ASSESSMENT REPORT

One Carrington Street (Formerly Known as 'City One') SSD 5824 MOD 4

This report is an assessment of an application seeking to modify the State Significant Development (SSD) approval for a transport interchange, commercial and retail development at One Carrington Street, Sydney.

1 Carrington Street (West) Elevation
 Scale: 1 : 200

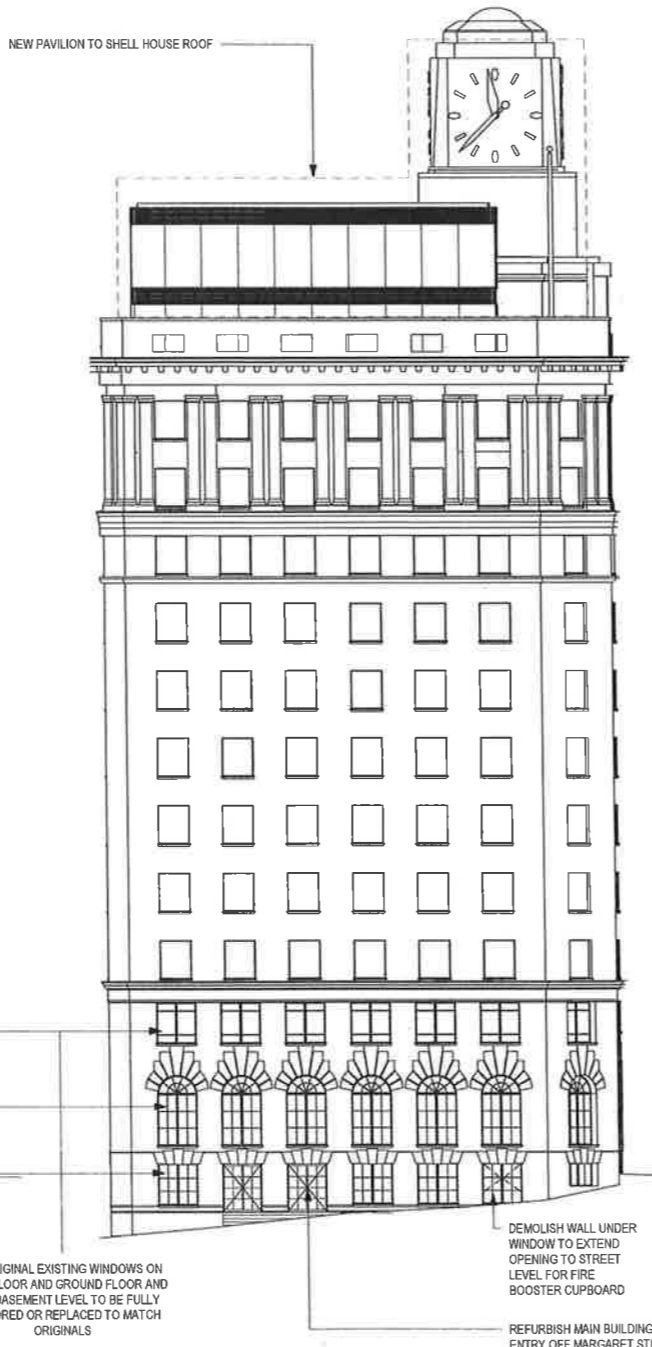
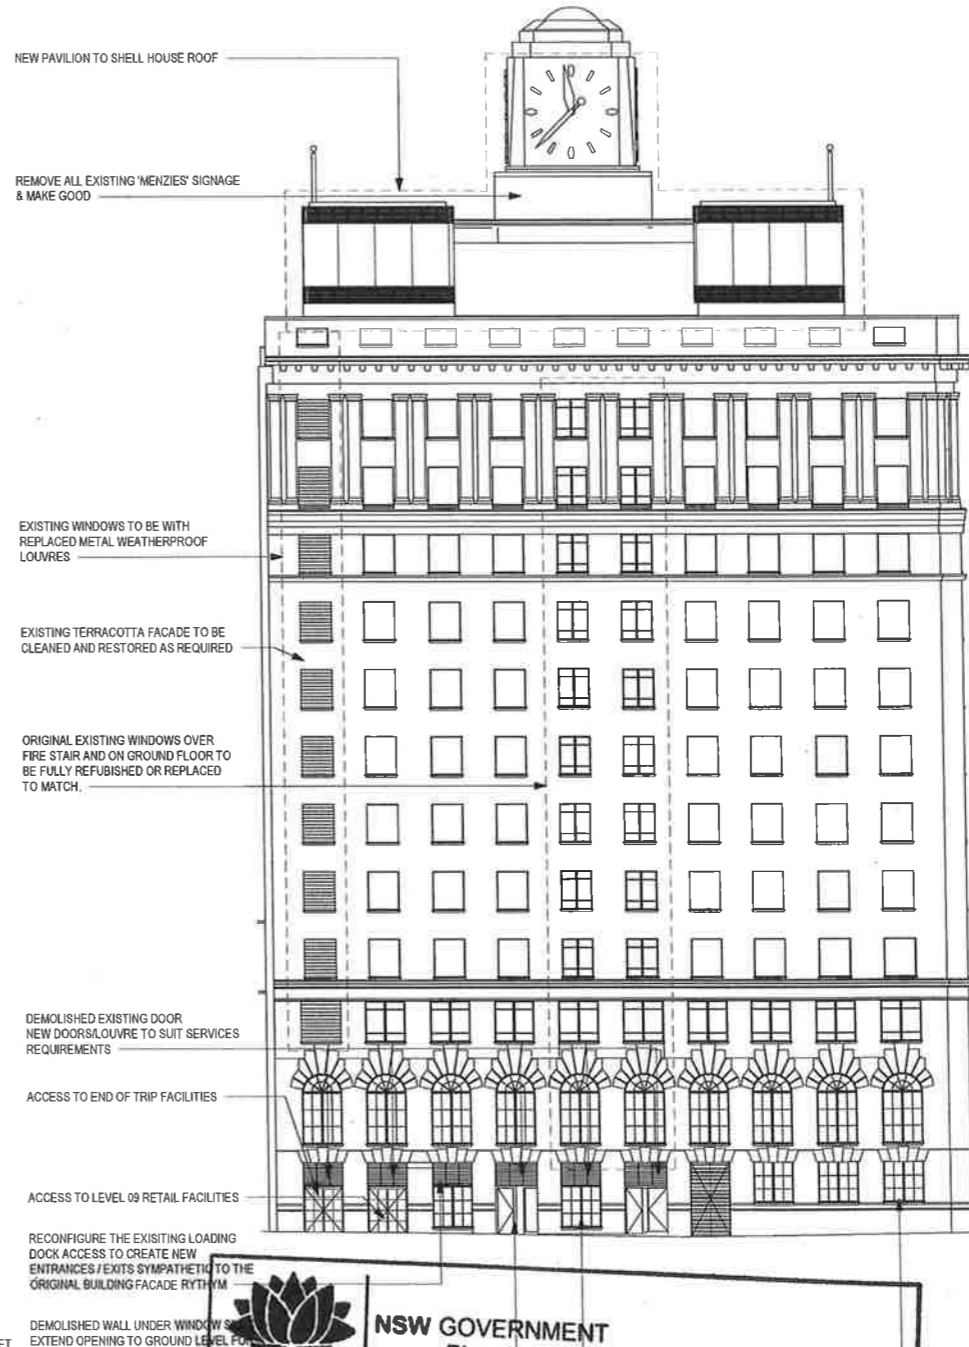
Council originally objected to the proposed removal of the three steel framed windows within Shell House to create new door openings, as these elements are highly visible and are key elements of the original Spain and Cosh design of Shell House.

- the proposed raised floors should minimise negative impacts on the perception of the internal space, views out to the tree canopy and ensure that daylight penetrates into the interior as much as possible. In addition, further analysis of proposed changes to window heads is required;
- the ground floor (single volume) lobby space should maintain the legibility of Shell House and proposed escalators should be designed to ensure that they do not erode Shell House's distinctive character;
- Council would support further efforts to enhance the visual prominence of the clock tower;
- further detail is required of the converted water tank/planter and green roofs;
- all trachyte should be carefully salvaged, and if not used should be stored at the Council's stonework yard; and
- the creation of a new doorway on the splay at the corner of Carrington/Margaret Streets is supported.

- adverse impacts should be mitigated through conservation of significant original fabric and the replacement of windows with doors should be carefully undertaken and consider the style/material of the original windows;
- external and internal alterations to Shell House are limited to the ground floor and will not impact on heritage items or places identified of state heritage significance; and
- the overall works will not impact on significant views to and from state heritage items or impact on the Aboriginal and historical archaeological potential of the site.

The following additional information relating to the Shell House is to be submitted to and approved by Council prior to the issue of the relevant Construction Certificate:

- (a) the ground floor layout plan including the proposed entrance treatment, proposed levels changes and interface with Carrington Street.
- (b) the detailed fitout design of the Shell House lobby space, including interface with the new tower to the south.
- (c) the detailed design of the works to the openings at ground level on Carrington Street.

Council considered the RtS and confirmed that it no longer objects to the proposal. Council now supports the modification application, subject to the imposition of the suggested condition.
